PLANNING - LEVEL III REVIEW (14-526): MMC Congress Street Medical Building (285KSF) (19 procedure rooms, 64 patient rooms, licensed bed count remains 637)
 Institutional Overlay Zone

IOZ - ZONING ANALYSIS

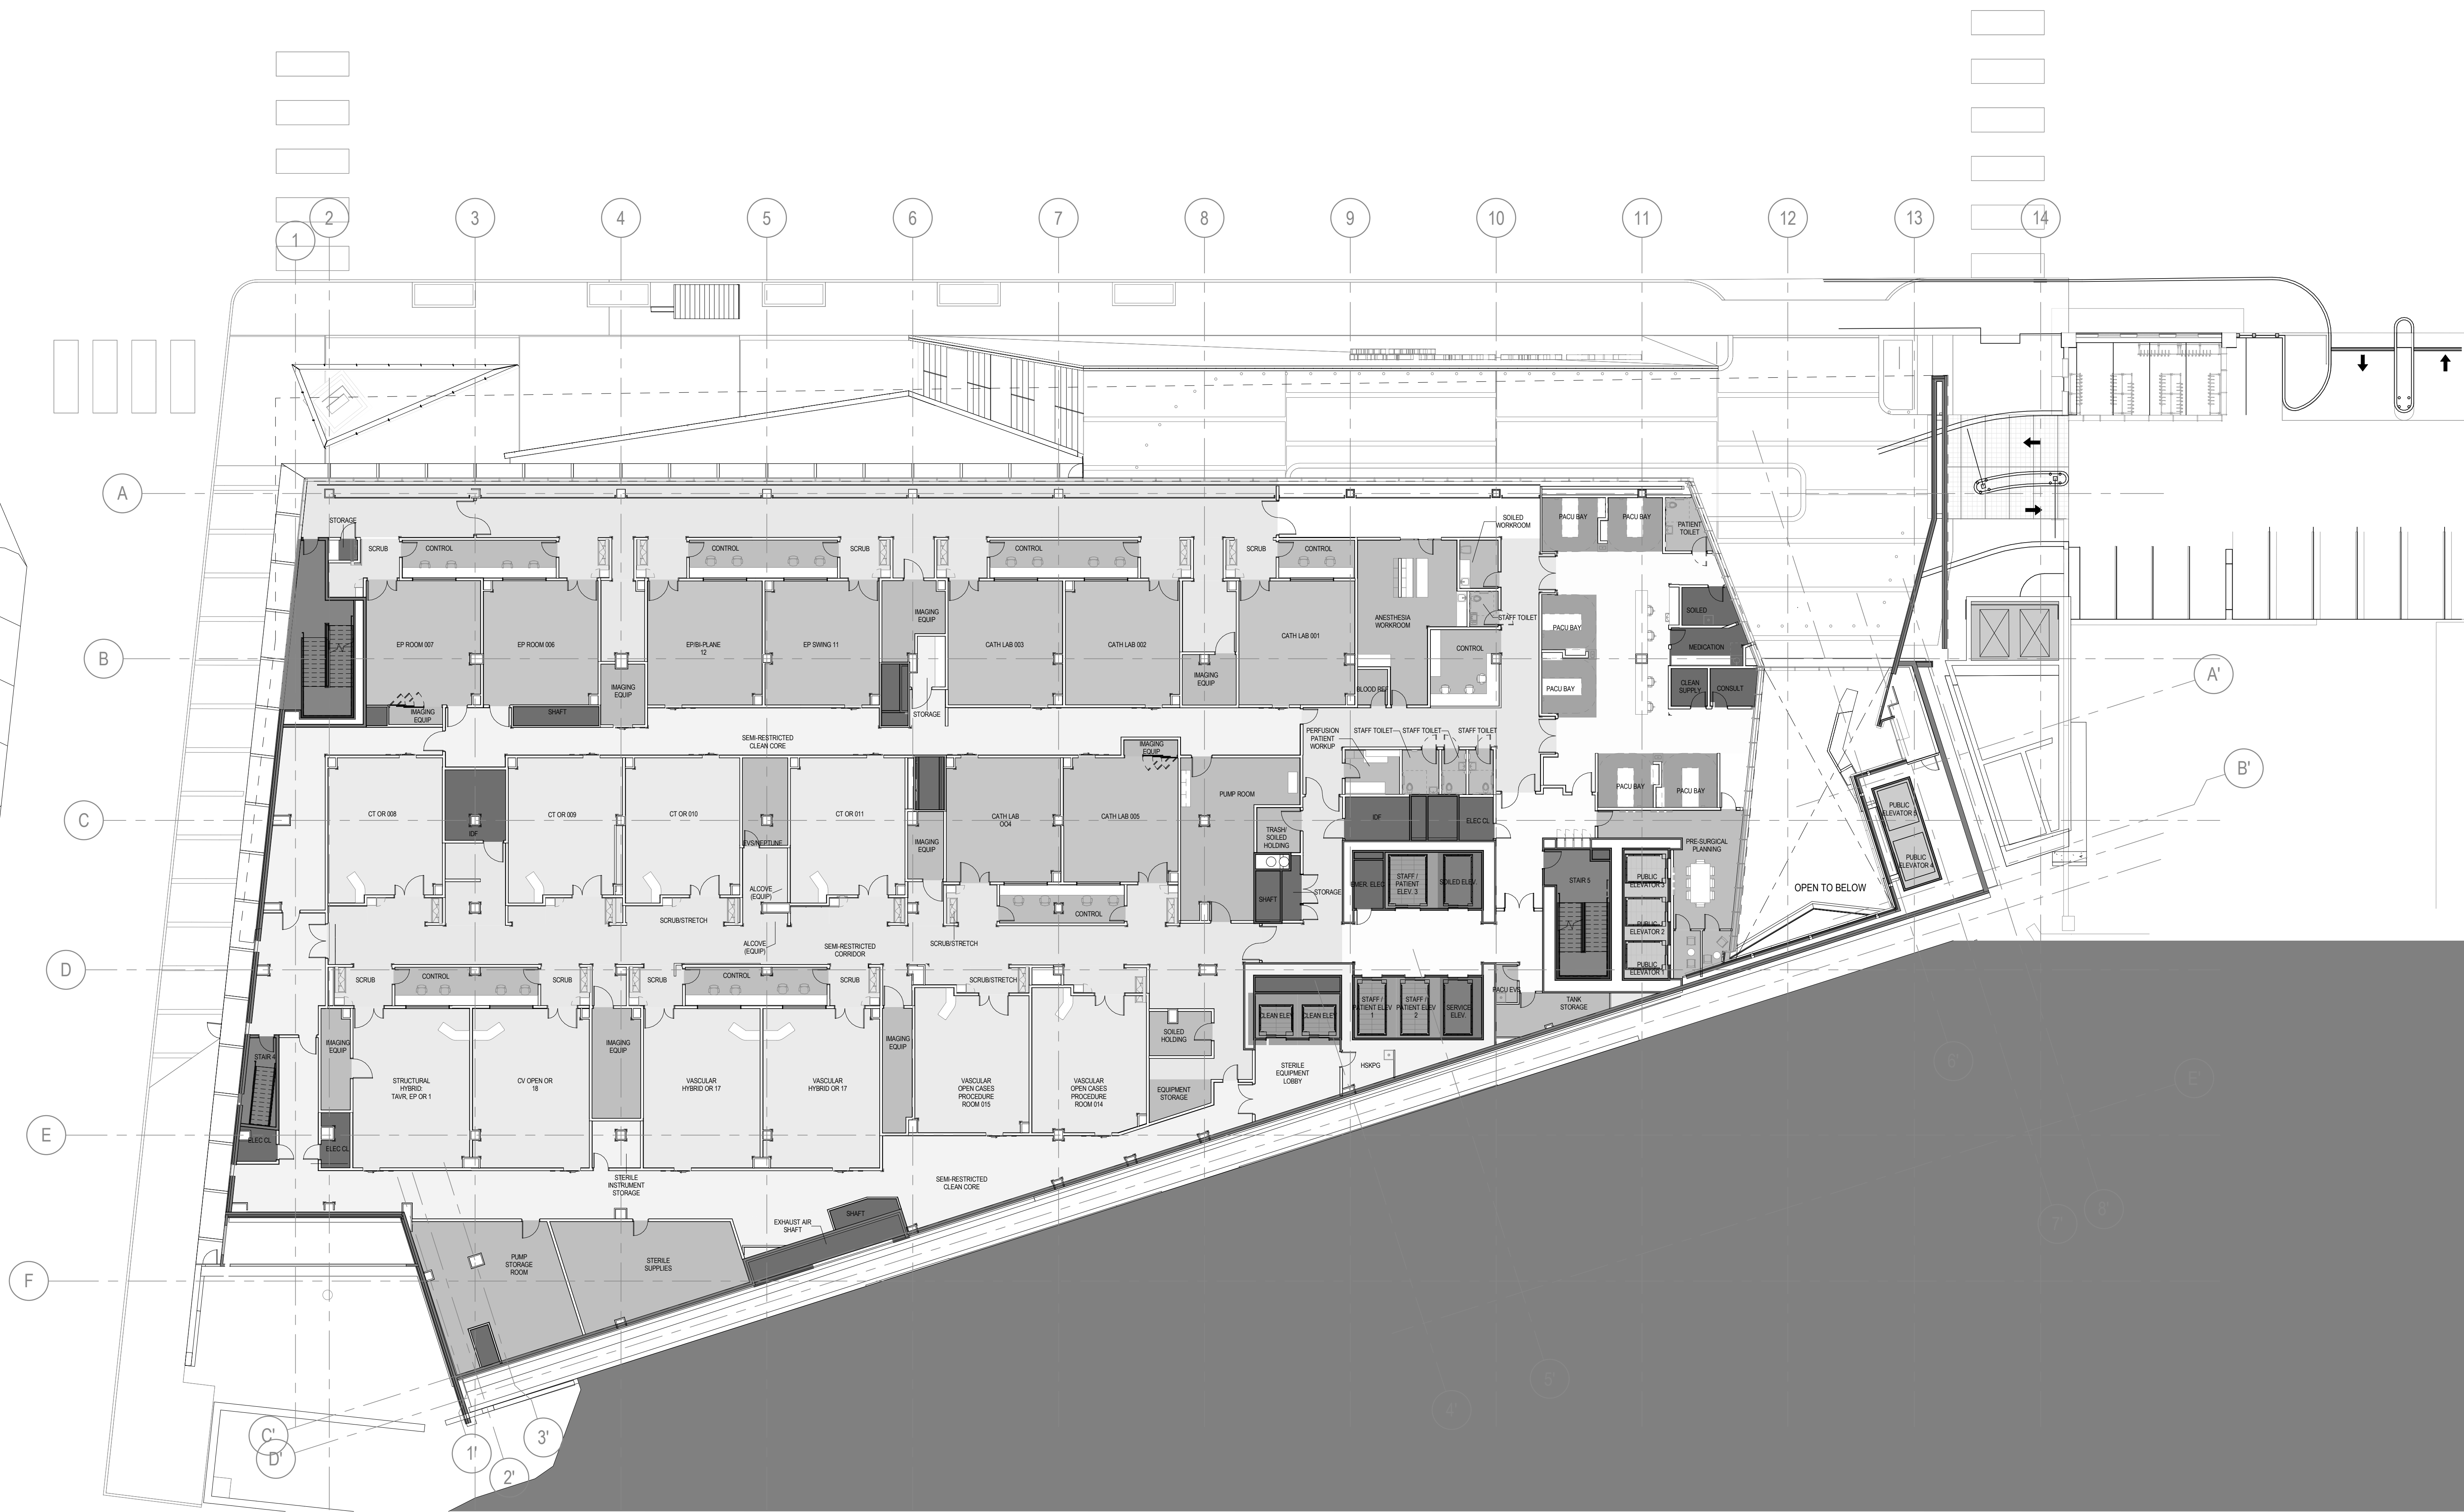
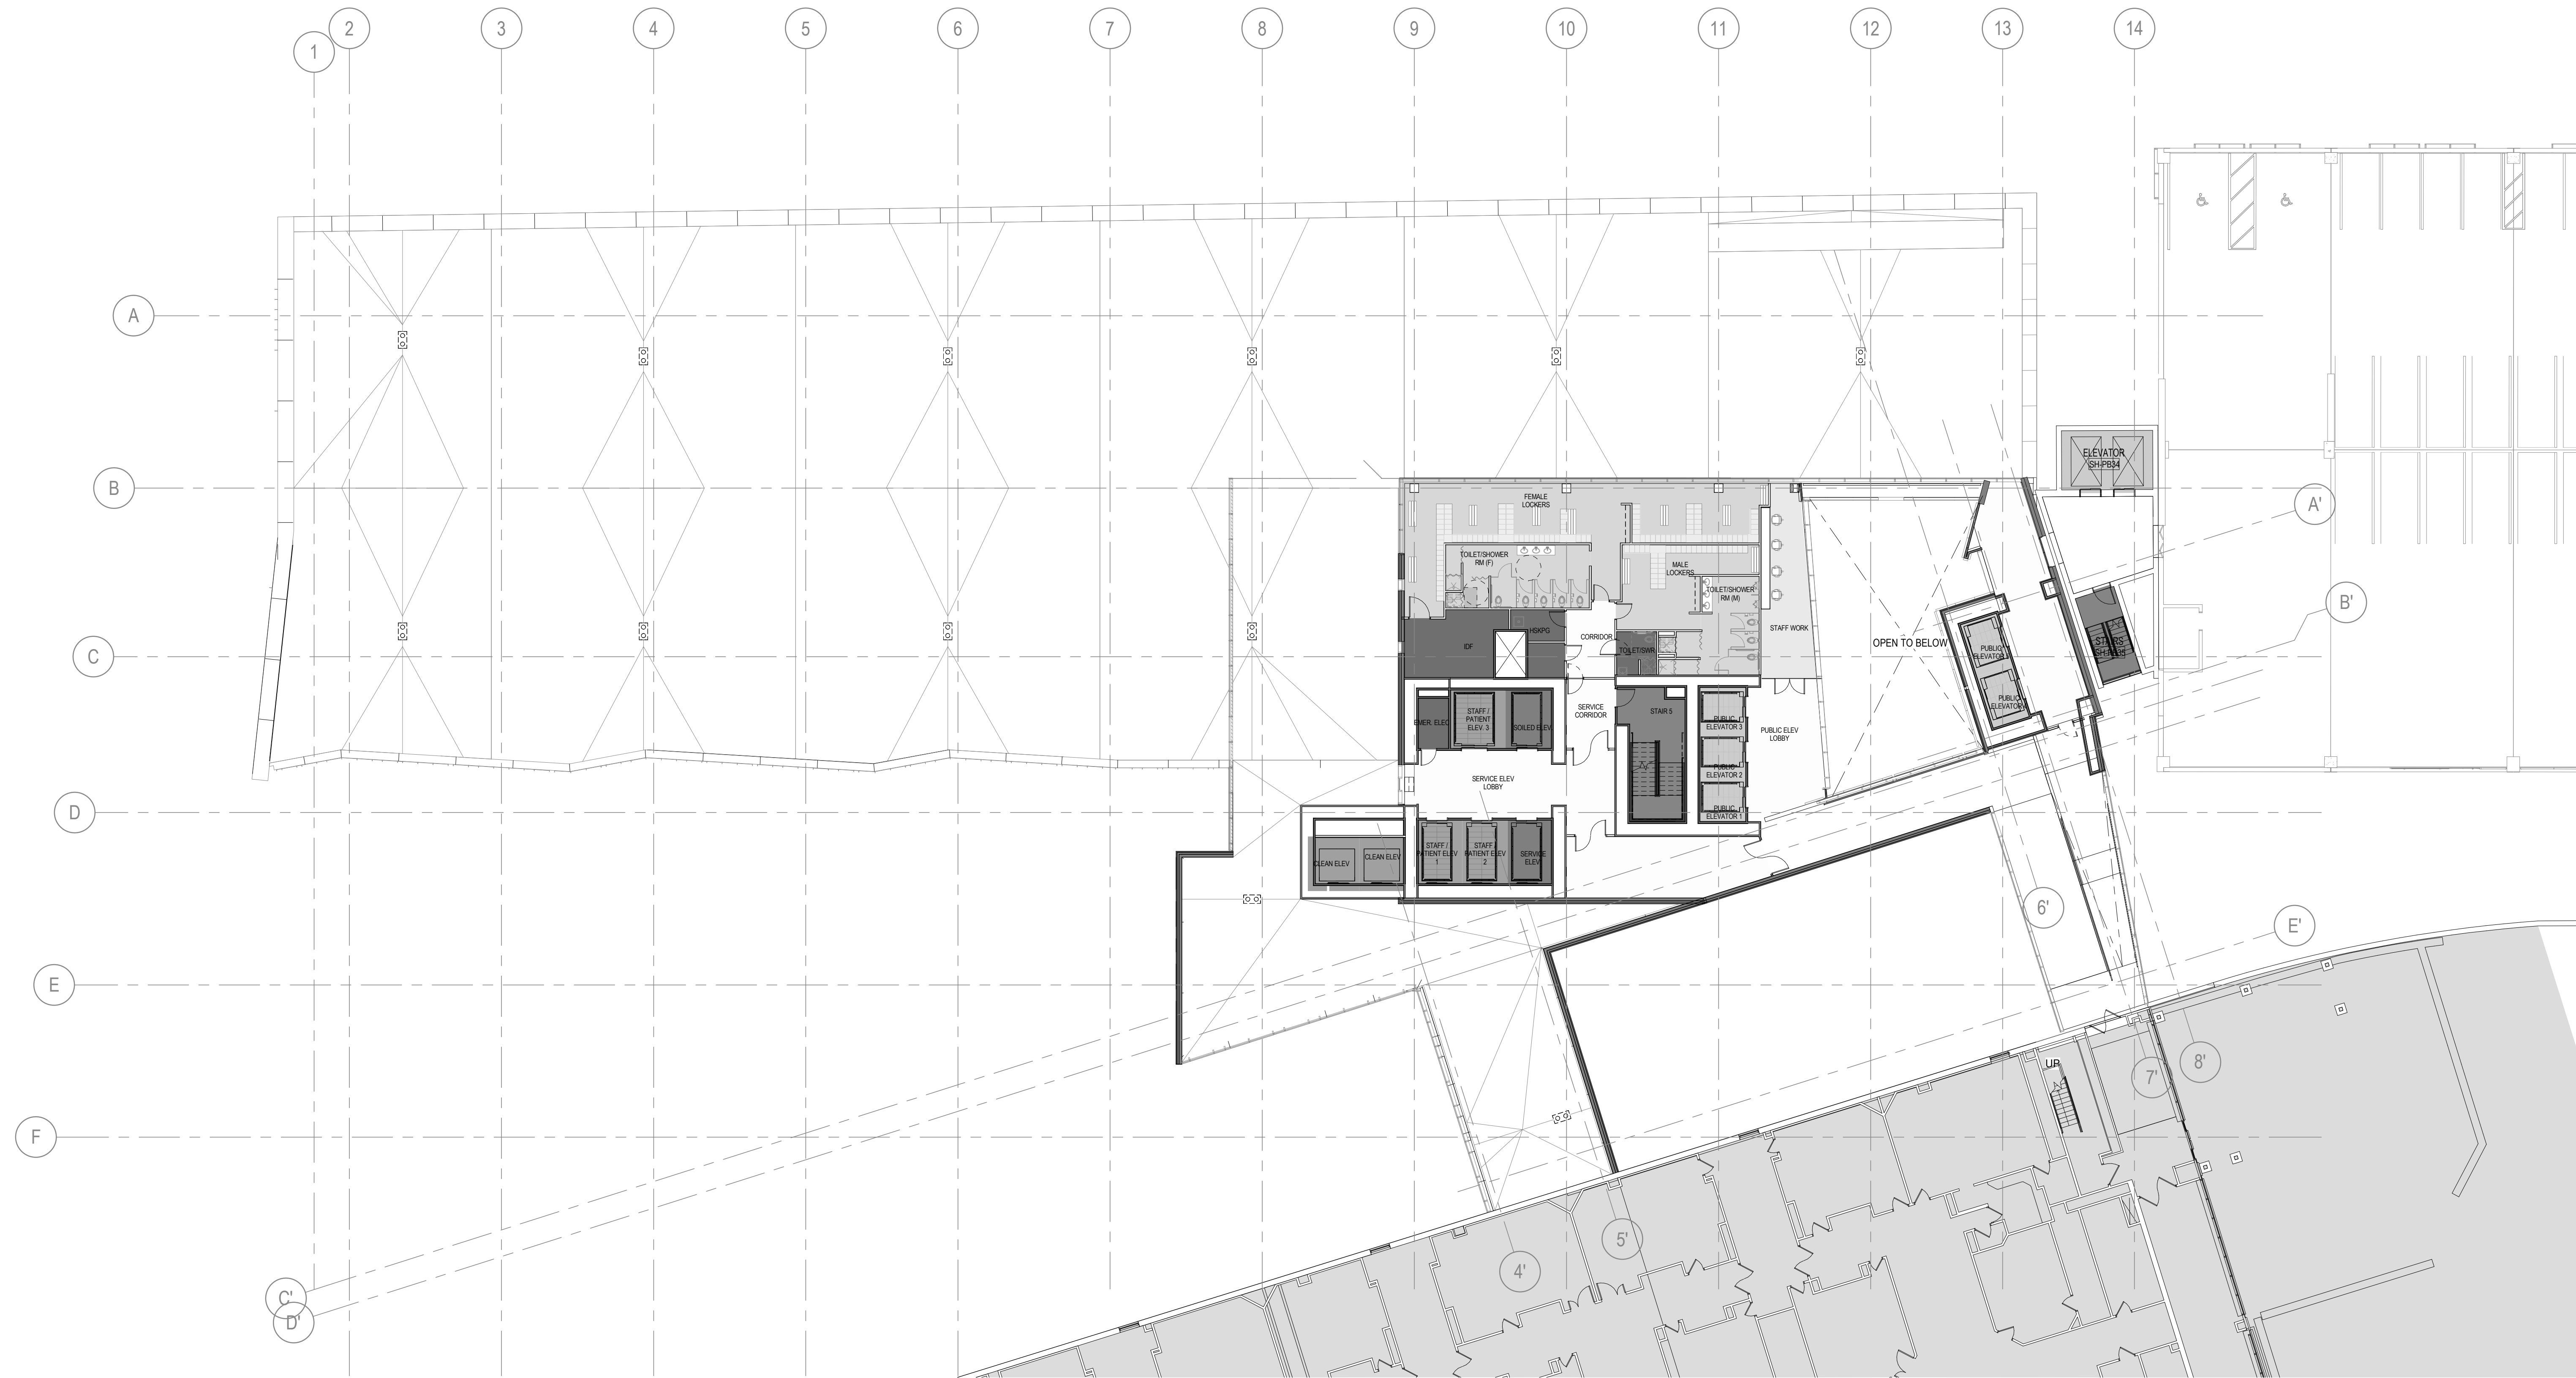
Please provide floor plans in revised submittal

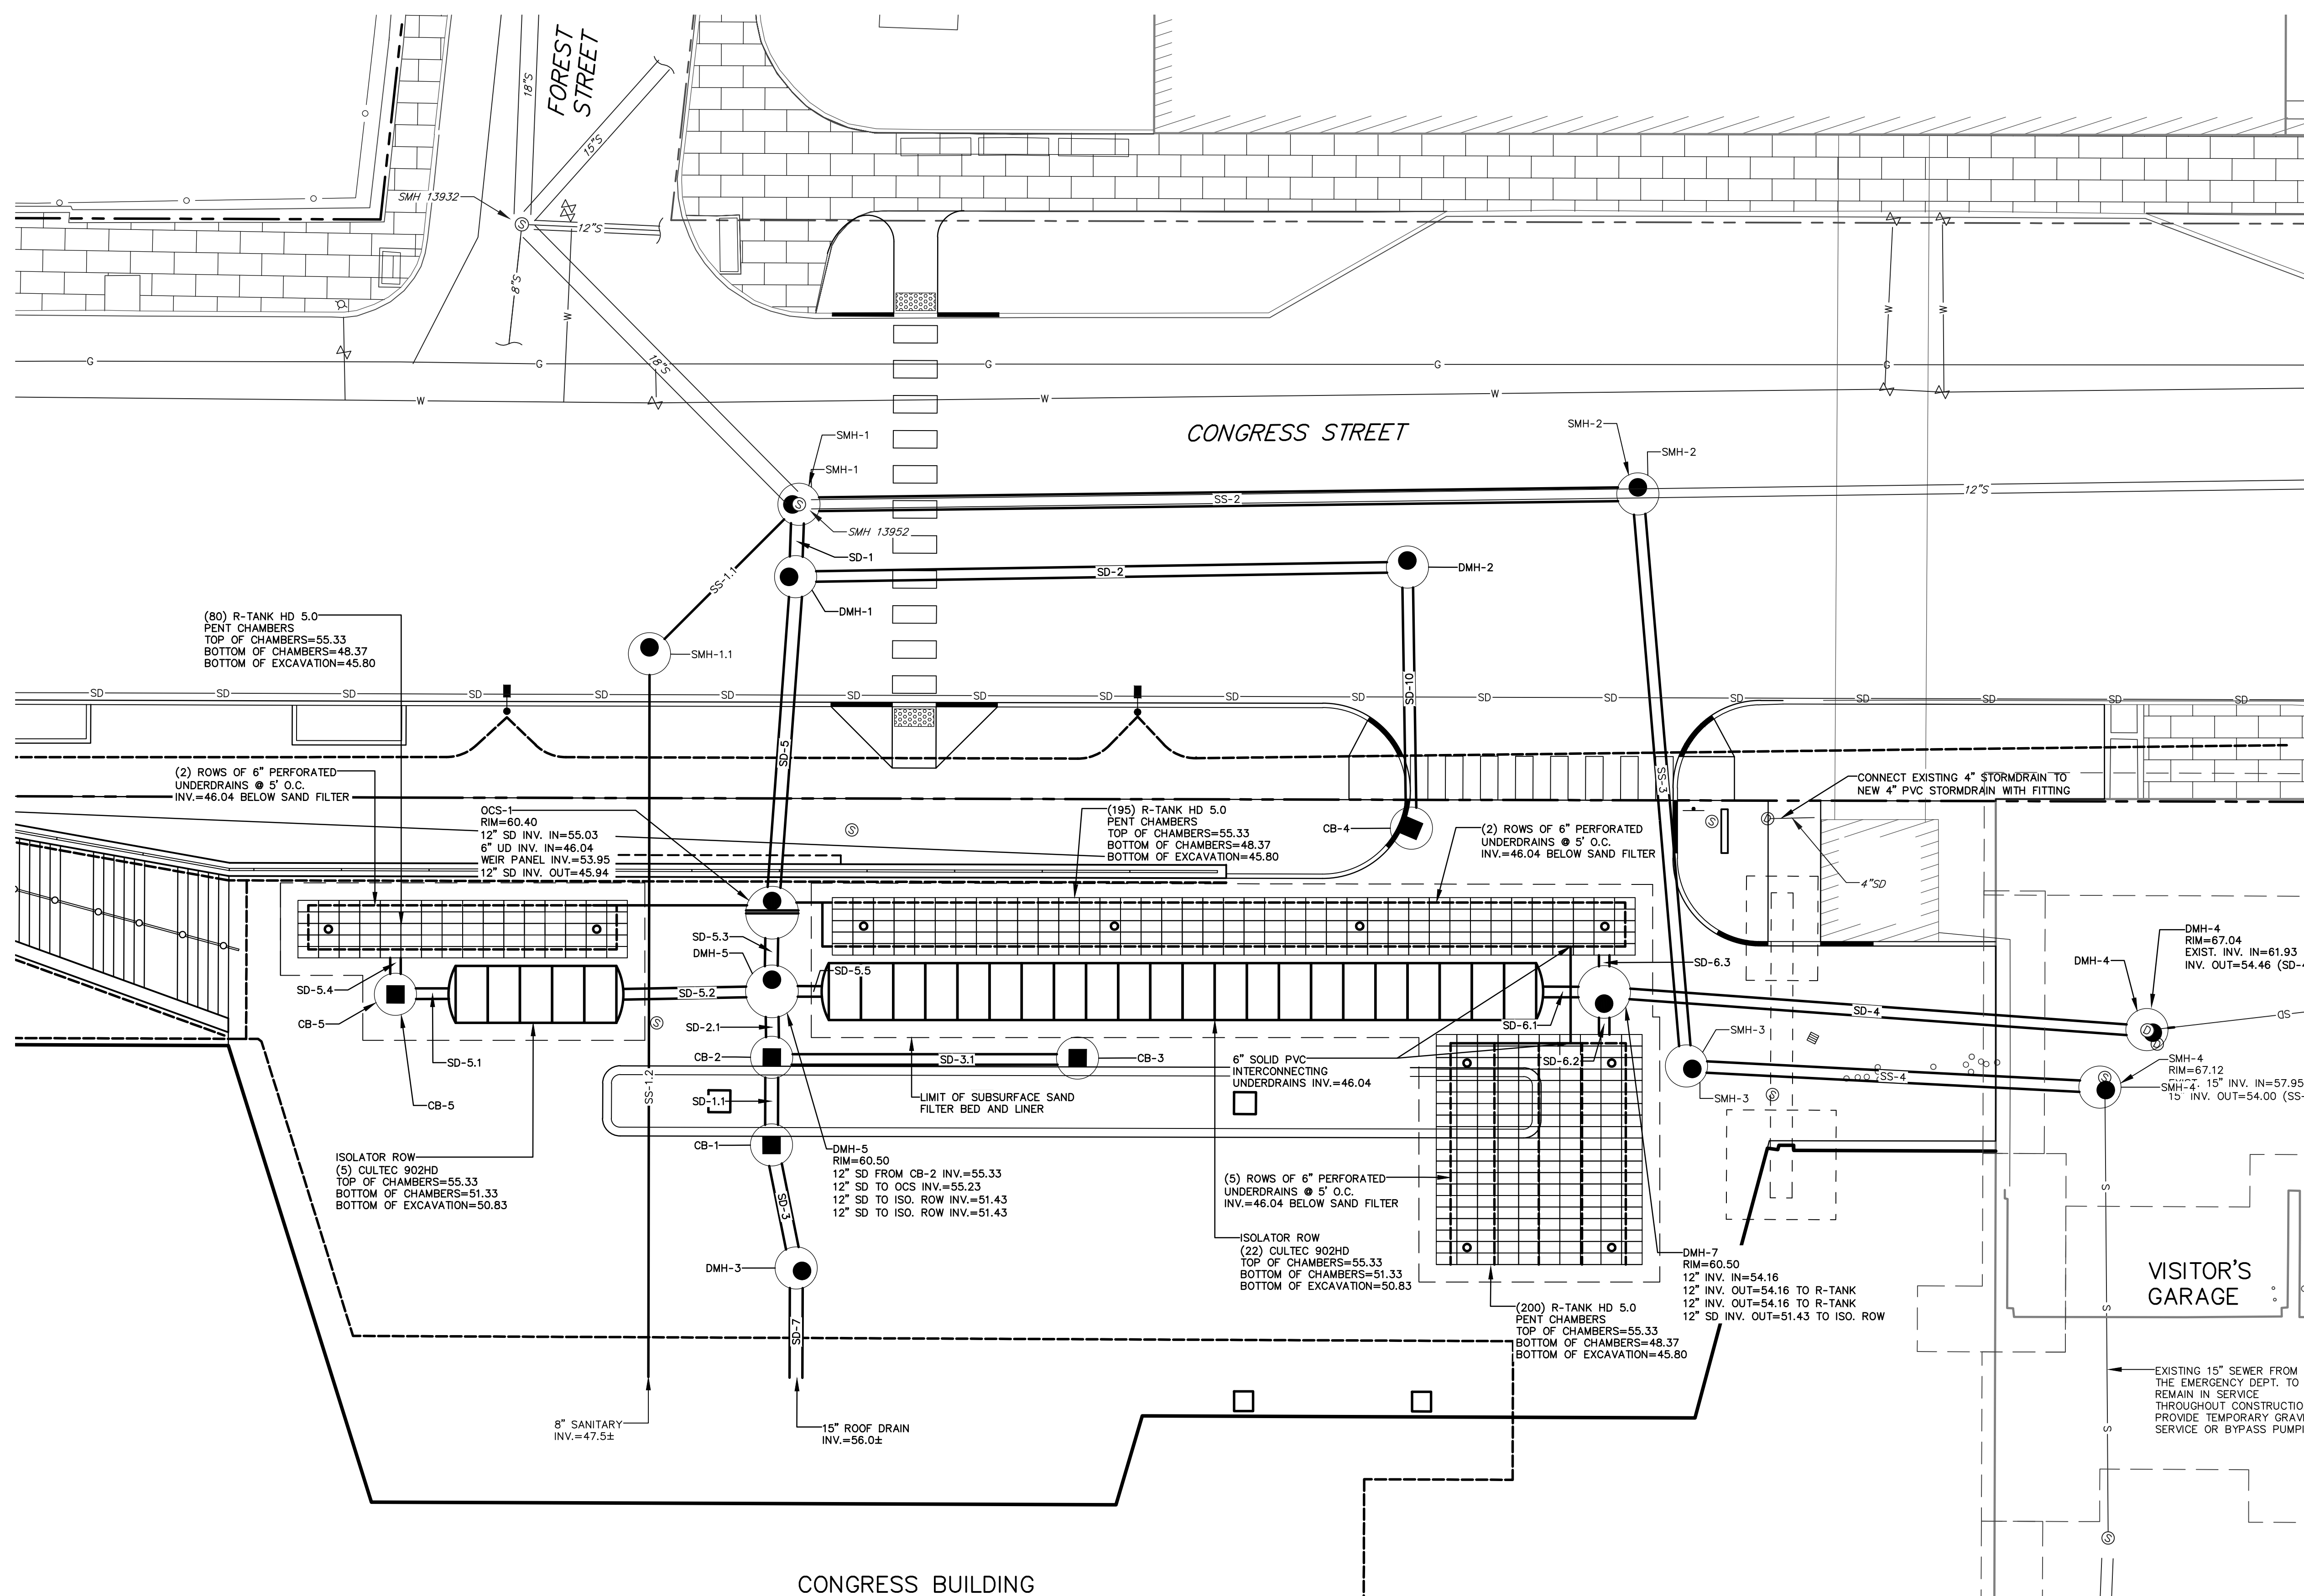
c. Availability and Adequate Capacity of Public Utilities	Utility plans are still under review.	See comments from others Please clarify extent of utility infrastructure in Gilman Street ROW, particularly electrical infrastructure?
Site Design	a. Massing, Ventilation and Wind Impact

- Can you confirm which utility poles are staying and which will be removed? Any remaining utilities & poles should be shown on the revised utility plan.
